TfNSW reference: REN 26/00015/001 – Mod 01

Your reference: SSD-29704663

SSD – 29704663, MUSWELLBROOK BESS PTY LTD Muswellbrook Battery Energy Storage System Modification 1 -

This attachment relates to TfNSW's response dated 13 March 2026 reference REN26/00015/001

APPENDIX 4: SITE ACCESS

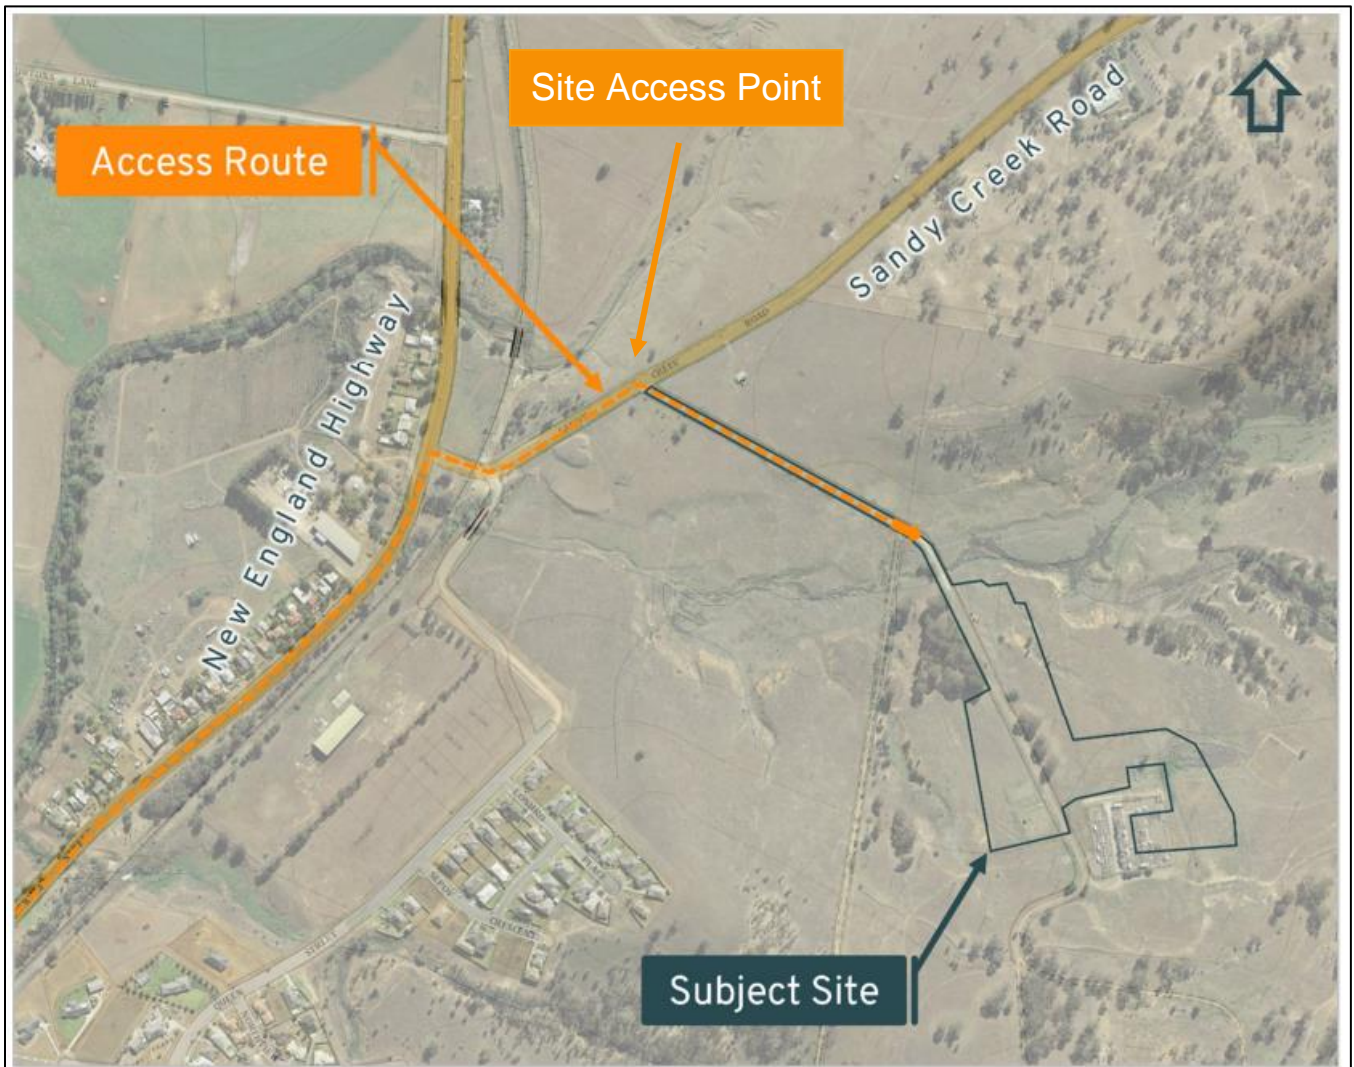
4.	<p>Applicable conditions to be amended and updated accordingly, including:</p> <ul style="list-style-type: none"> • B1(b) • B8 Traffic Management Plan to be updated. <p>Appendix 4 should include additional haulage routes.</p>
